Re: 21 Hawke Close
Rustington

Ref. R/151/14/HH.

We wish to advise you of our objections to the retrospective planning application for the above property which is built at the rear of part of our back garden.

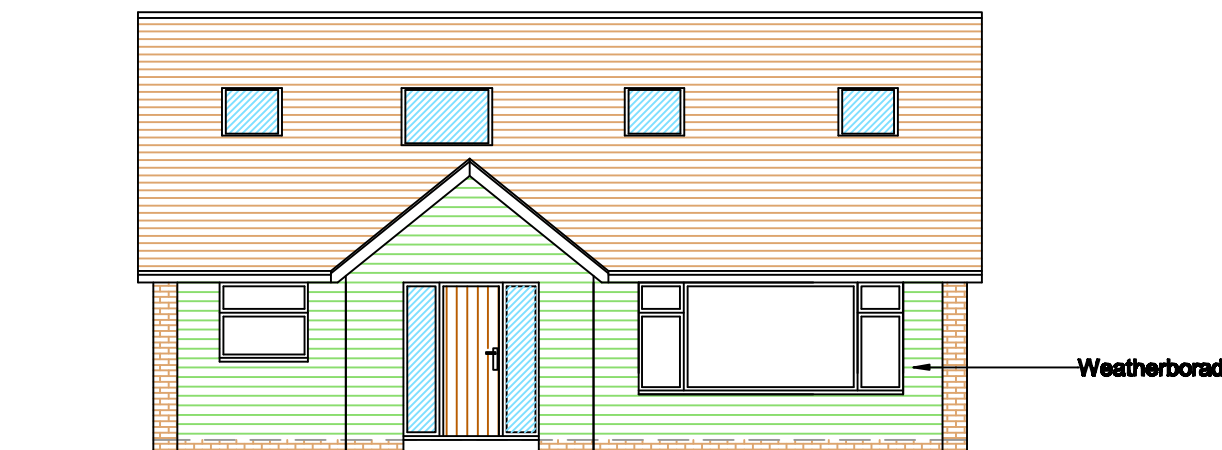
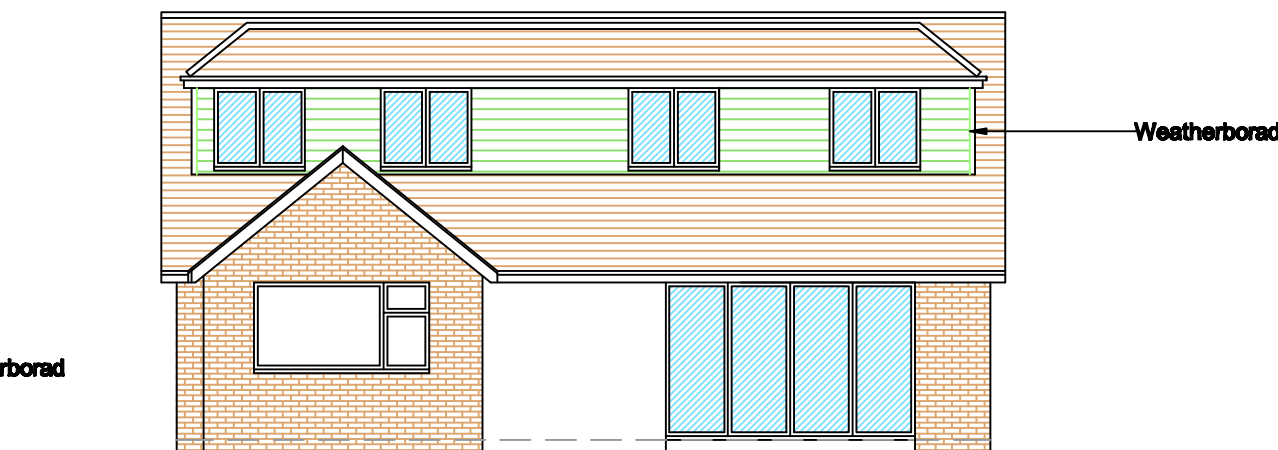
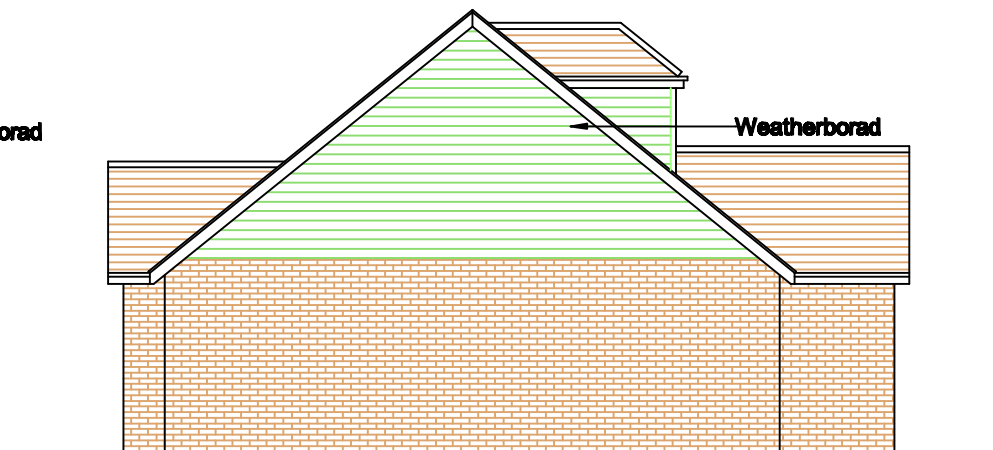
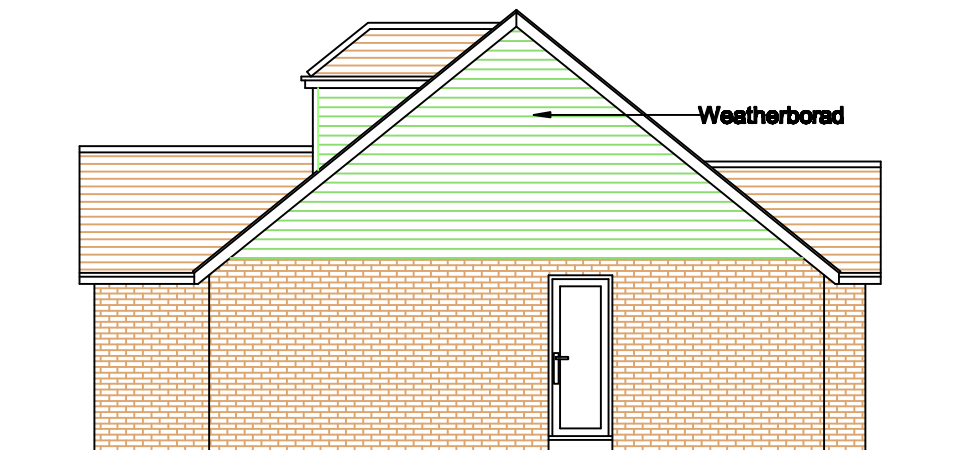
1) the cladding used is not in keeping with the surrounding properties.

Proposed First Floor Plan. Scale 1:50

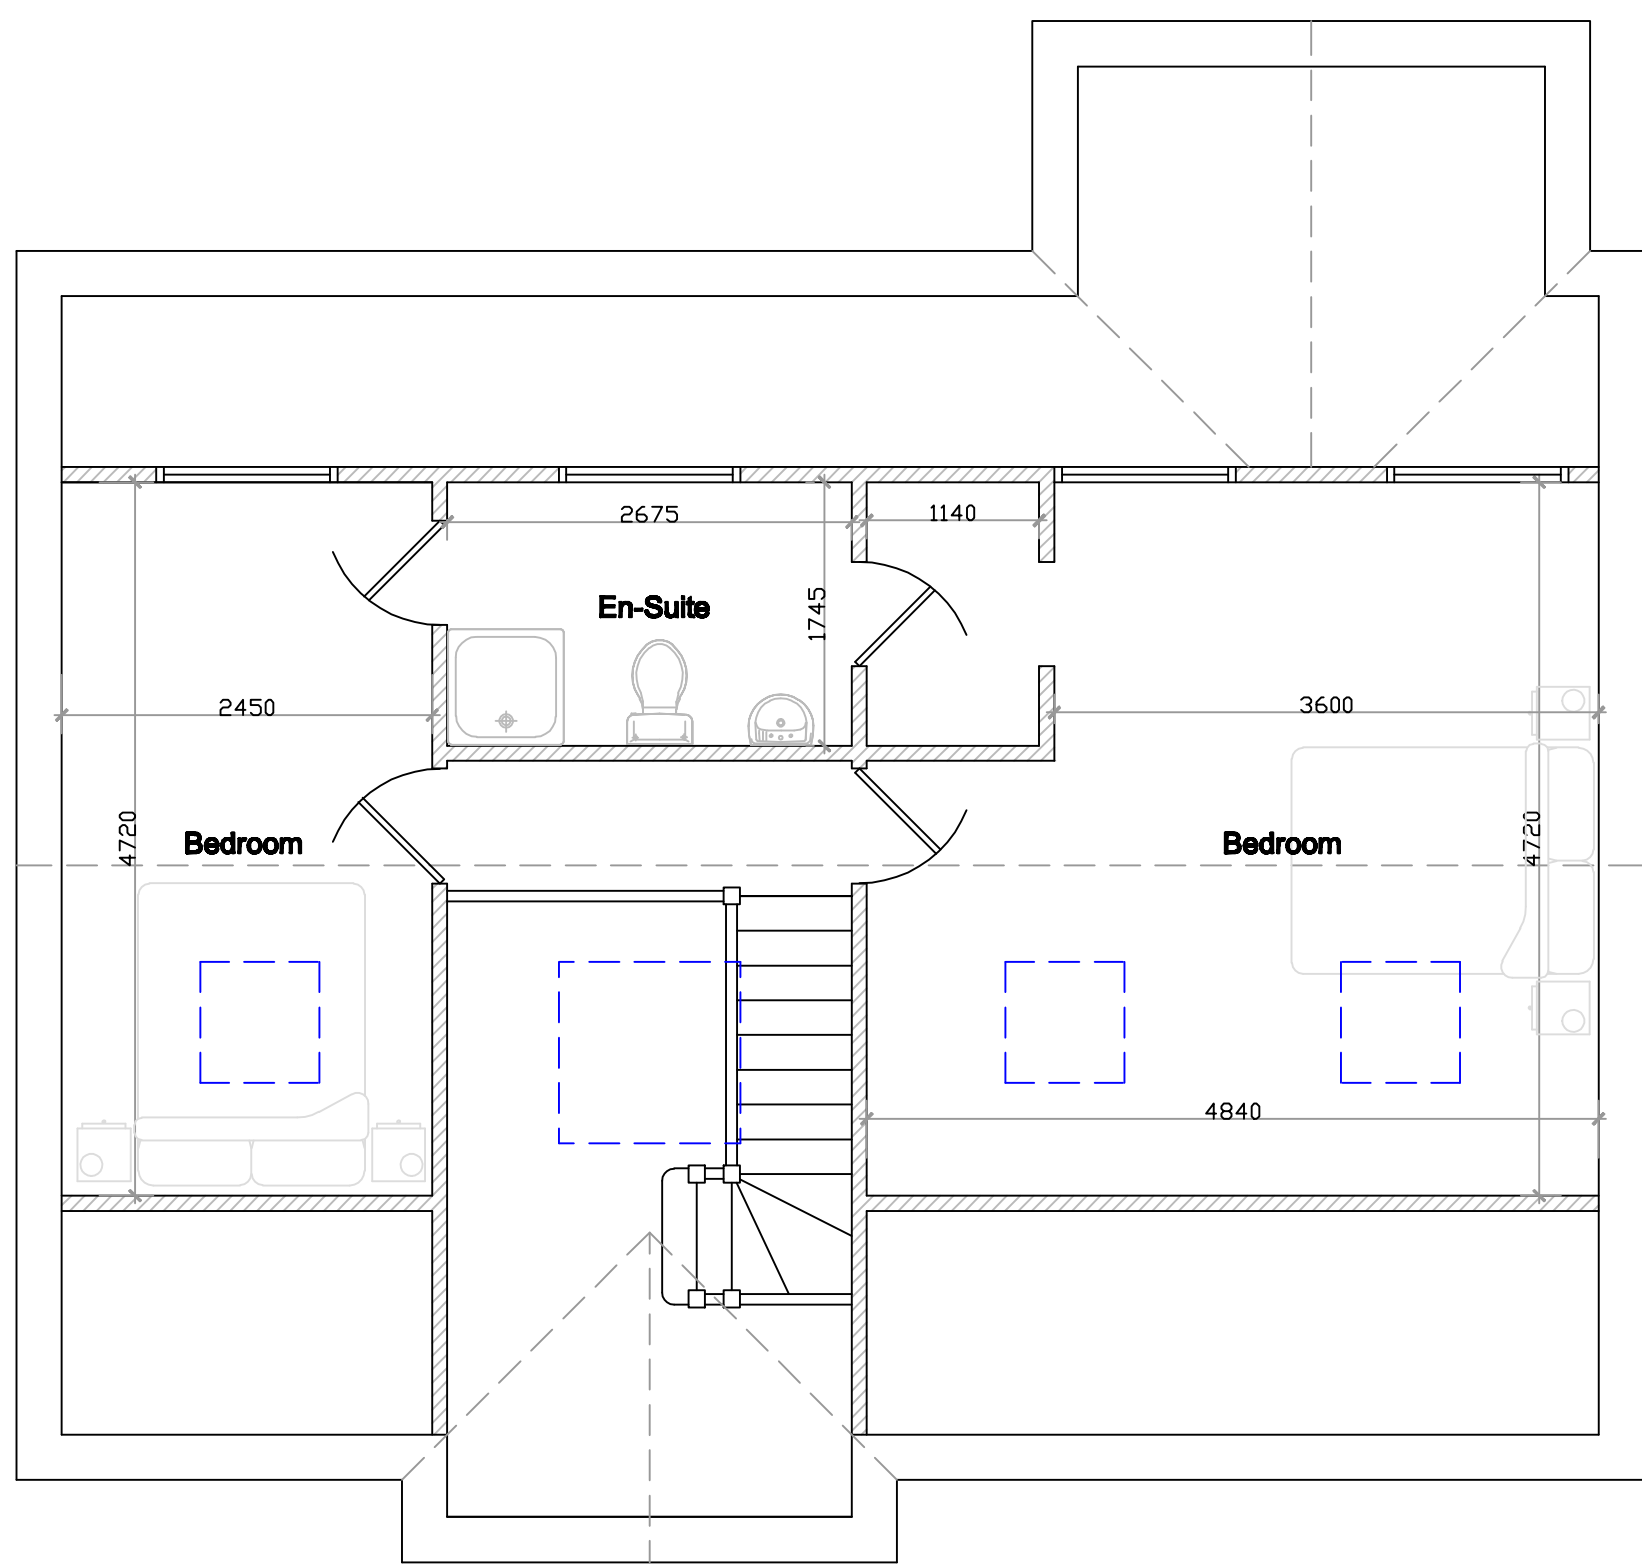
Since the alterations have been done, 2 rooms have been built in the roof space, we are objecting on the following grounds:

2) we now have four separate windows which overlook our property & garden, so we have lost the complete privacy we had as both our gardens are short in depth.
